From: Grace Palmer [REDACTED]
Sent: 02 February 2022 11:54
To: Simon Davis
Cc: Christopher Best; Lauren Wiltshire; Tom Moody
Subject: RE: Land at Northfields Cottages, Eastergate BN/1/22/DOC
Attachments: 108.5009MMS3Land at Fontwell Avenue, Eastergate - SuDS Mgmt and Maint Plan(Bound).pdf; 108.5009 - PLOT 15 1in100rev a.pdf; 108.5009 - PLOT 18-20 1in100 rev a.pdf; 108.5009 - Plot 18 19 & 20 1in10- rev A.pdf; 108.5009 - Plot 15 1in10 Rev A.pdf

Subject: RE: Land at Northfields Cottages, Eastergate BN/1/22/DOC

WAVIN AQUACELL INFILTRATION CRATES DETAIL

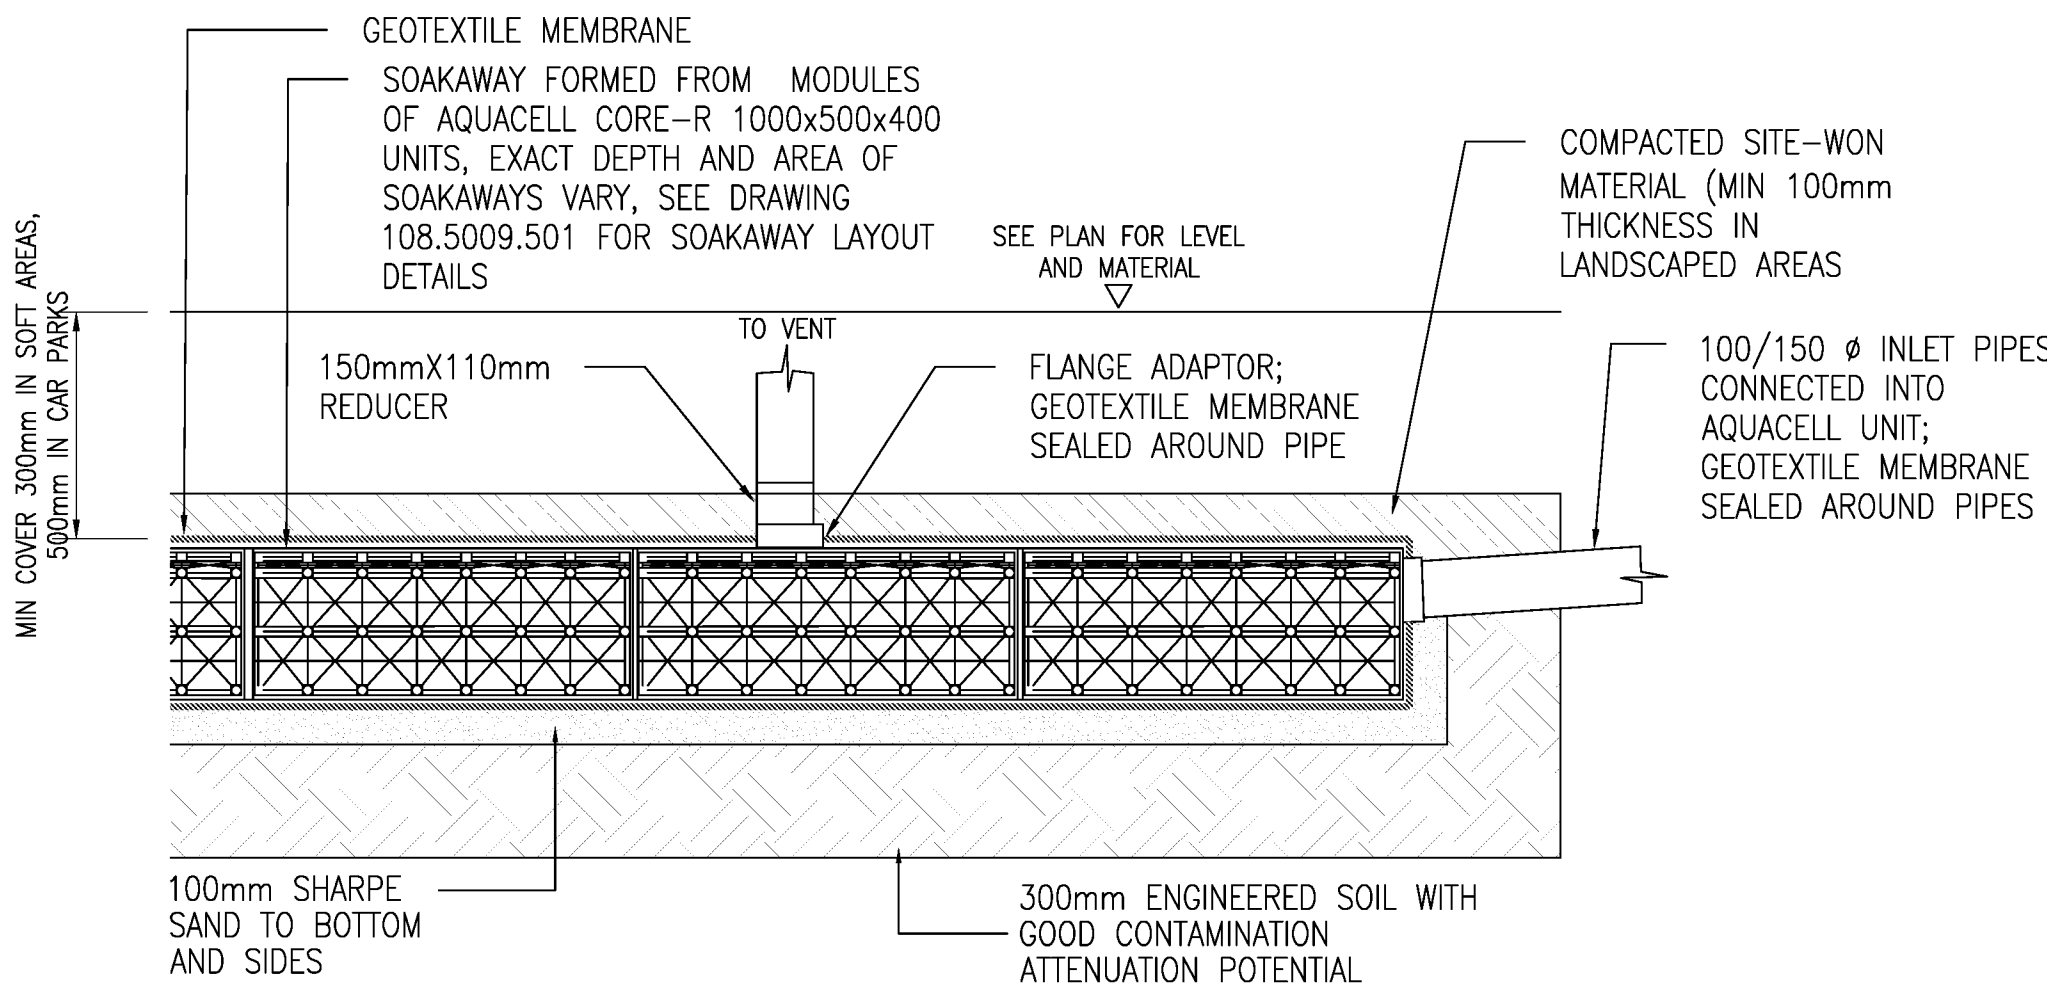
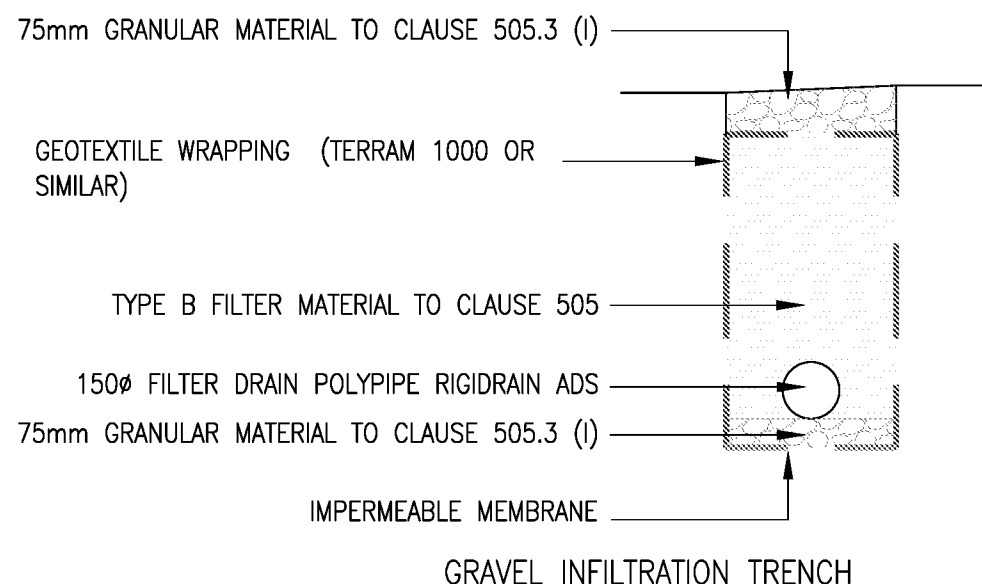
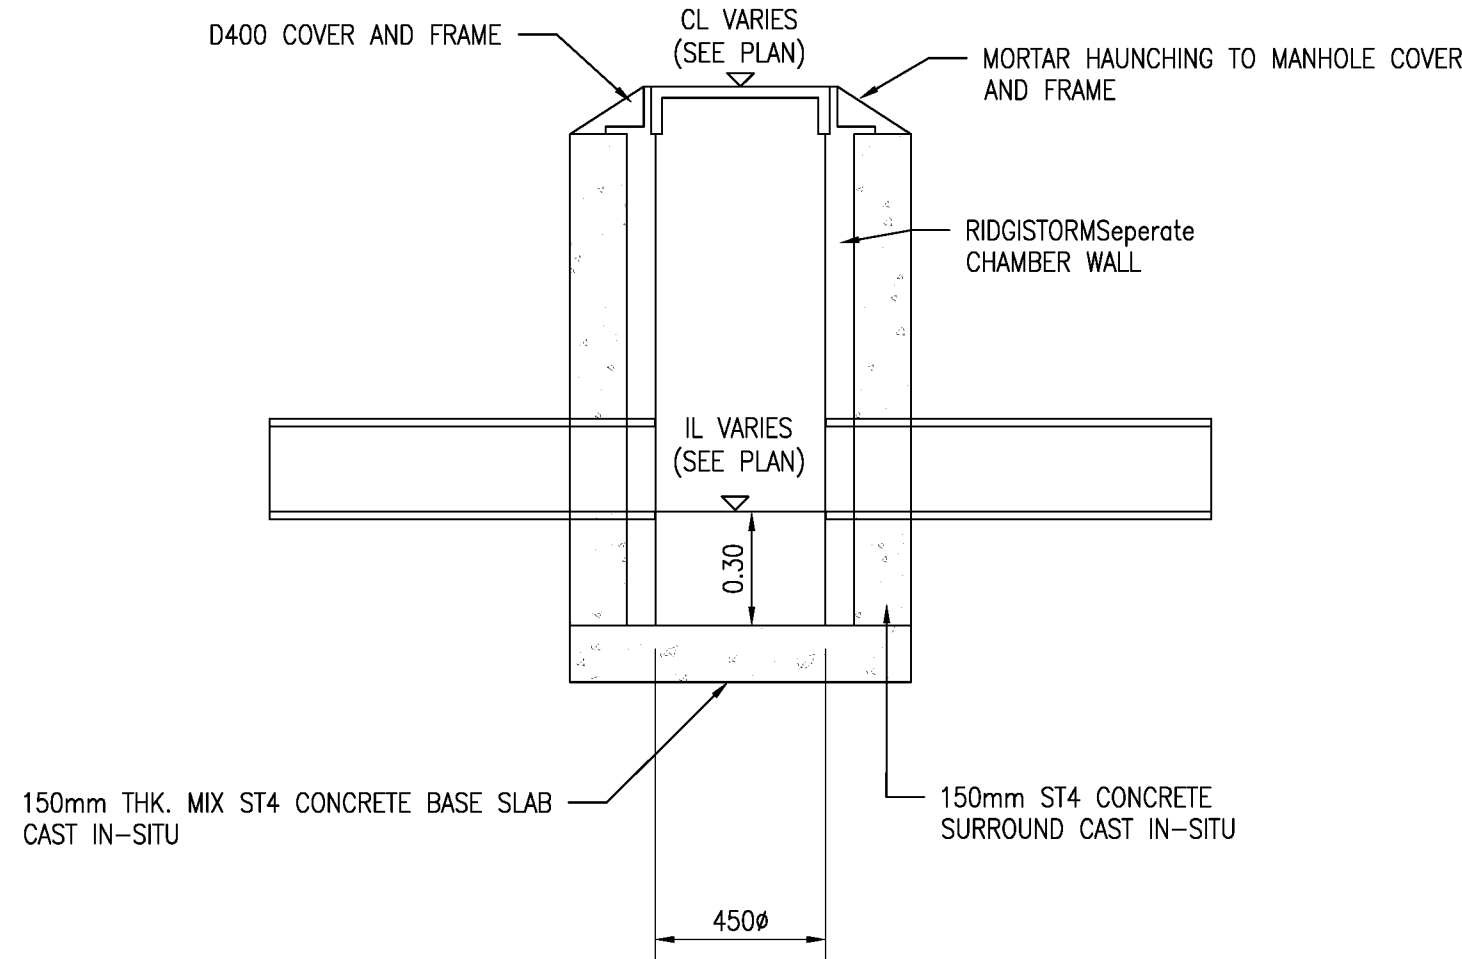
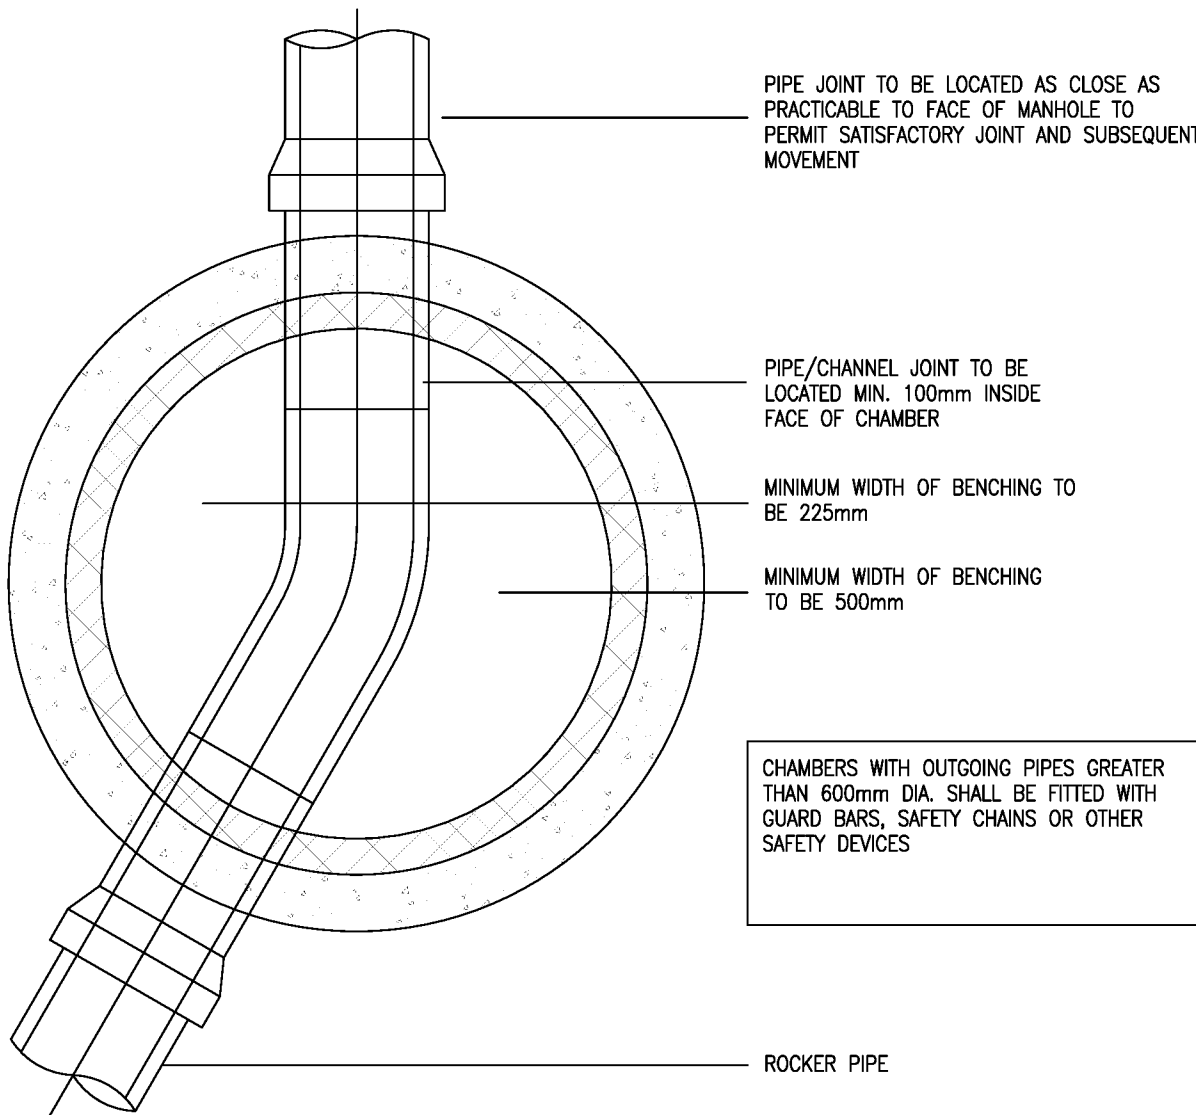
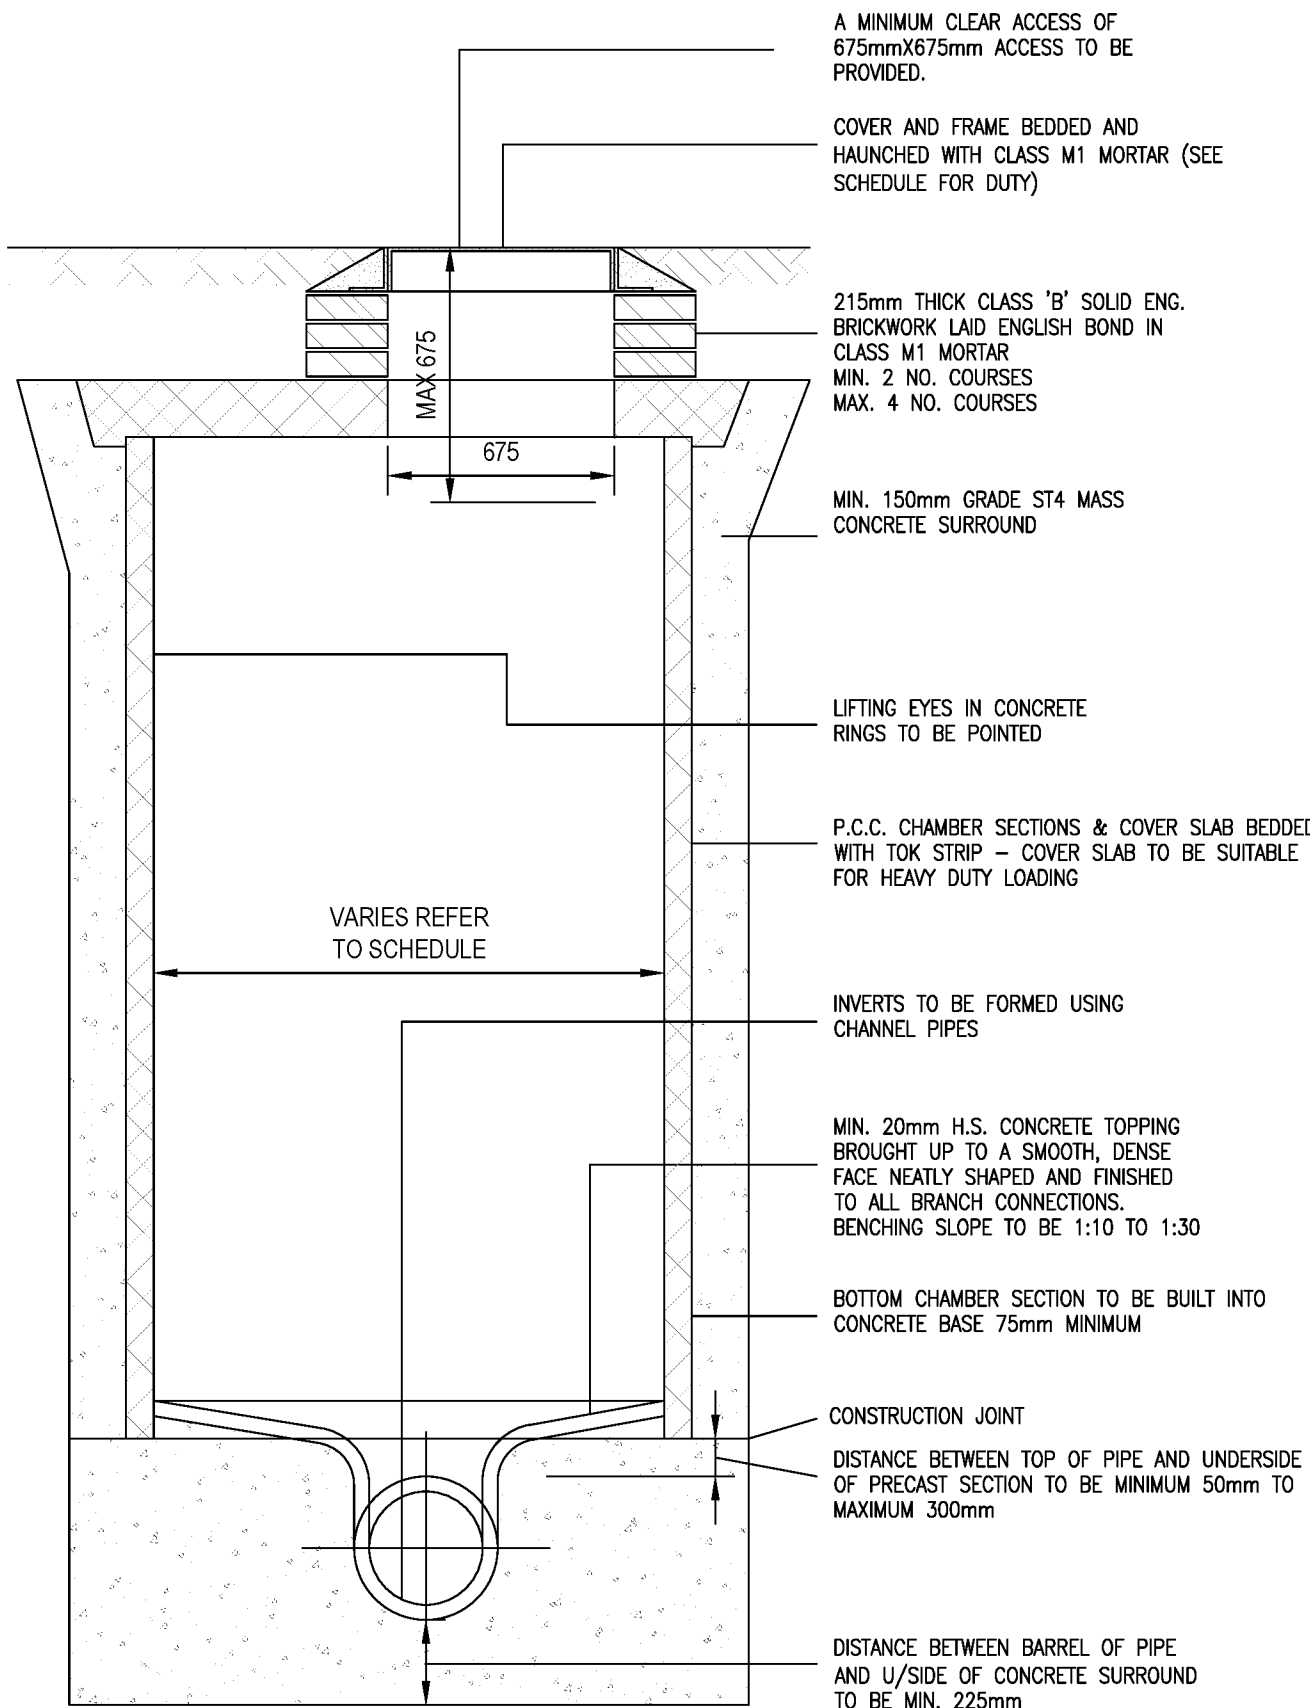
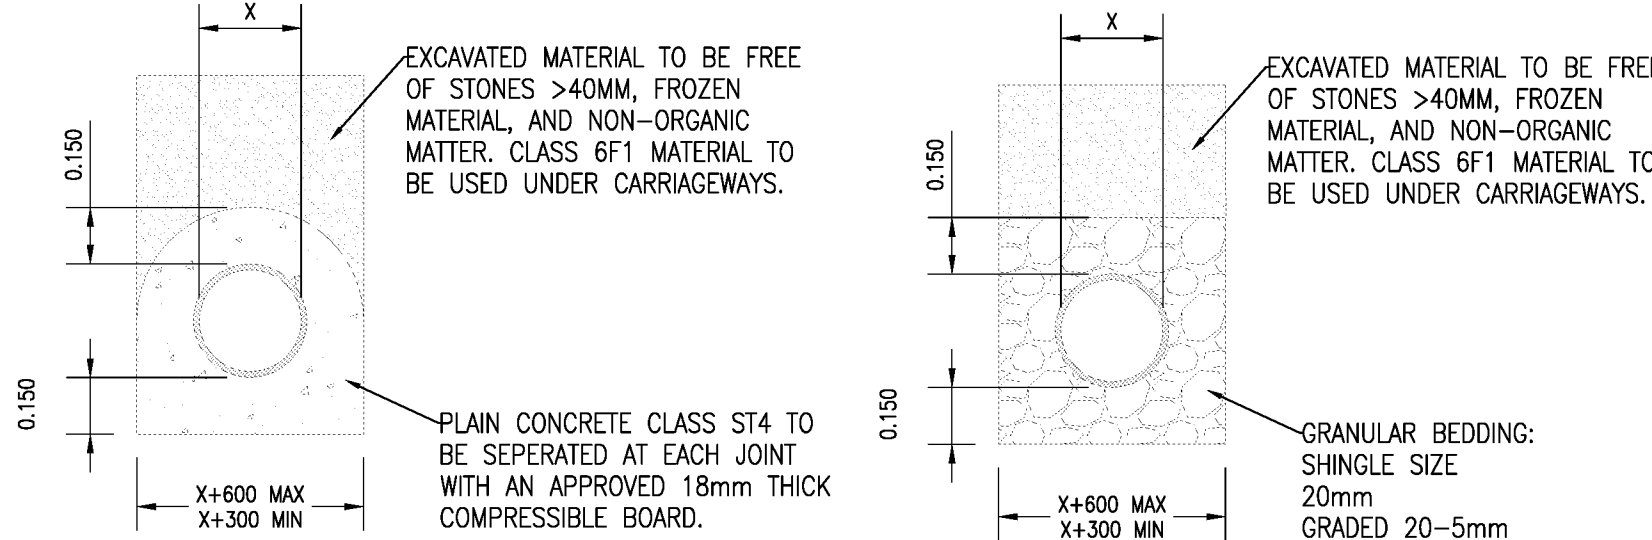
- A revised construction detail drawing of the soakaways has not been provided as previously requested. Drawing 551 Ref F was included in the recent resubmission, this was amended to incorporate the last comments from Laura. And is on the portal
